Submission to Preferred Project Report for Proposed  
Mixed Use Redevelopment

by Leichhardt Council

Balmain Leagues Club Precinct

Job No: 9071af  
December 2012  
© Willana Associates Pty Ltd 2012  
ABN 93 868692799

Photomontage 3 | View from Victoria Road, near Terry Street.

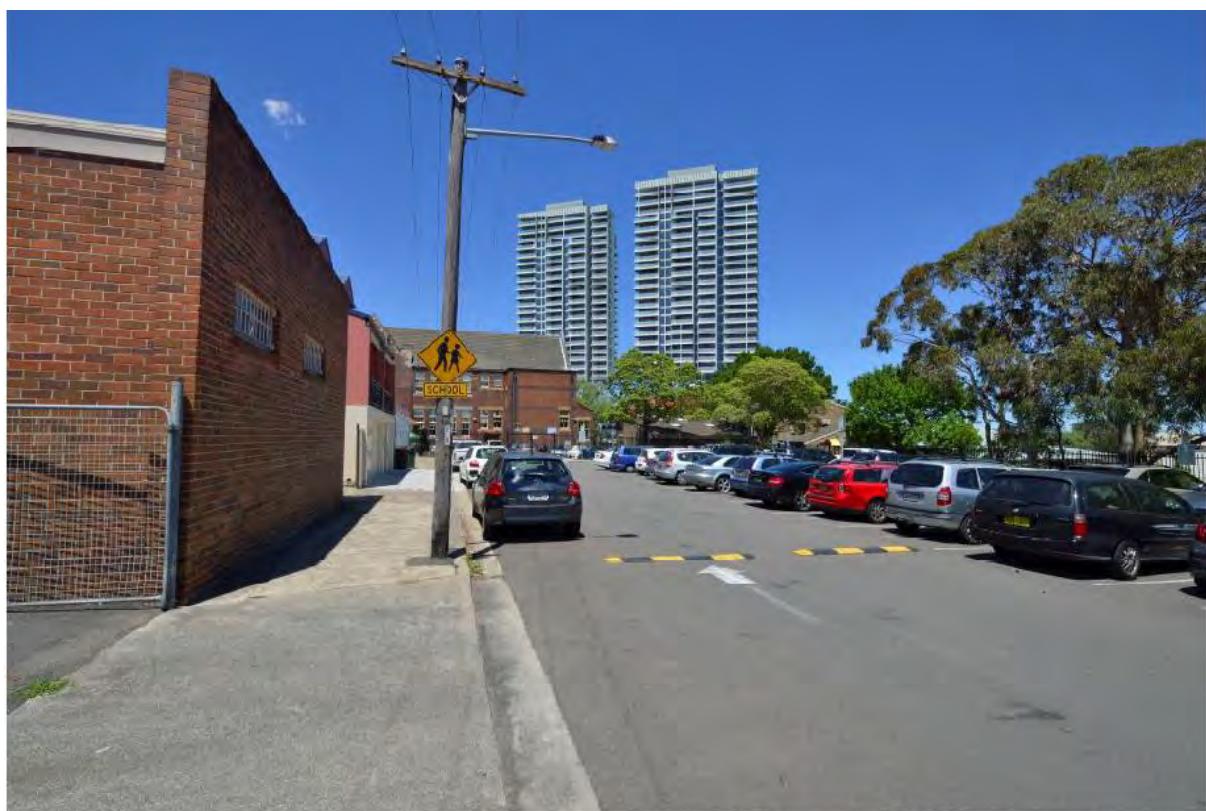
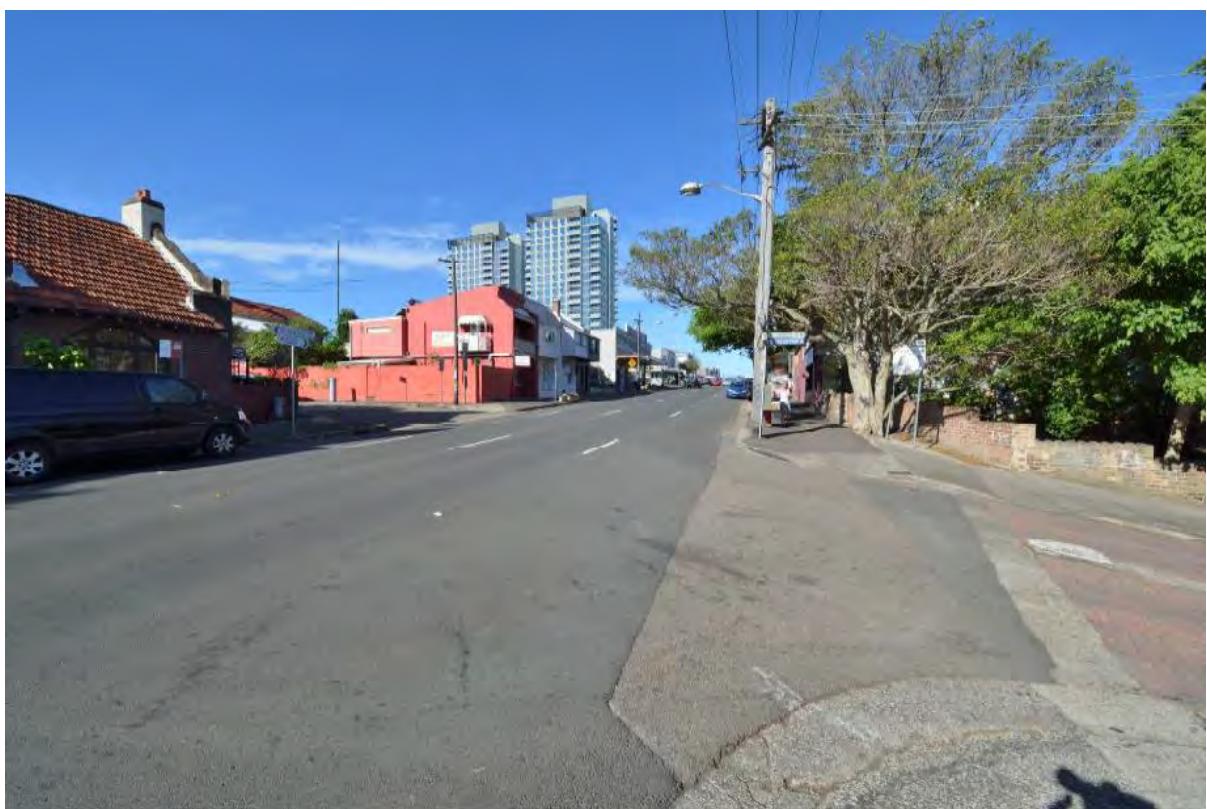
*A series of photomontages were commissioned by Council to demonstrate the possible contextual outcomes of the proponent's Preferred Project and the visual impact of the towers, given the site's location at the high point of the locality. Photomontages 1 – 4 on the following pages illustrate the visual impact of the development on the locality. A complete set of photomontages commissioned by Council are provided at Appendix A.*
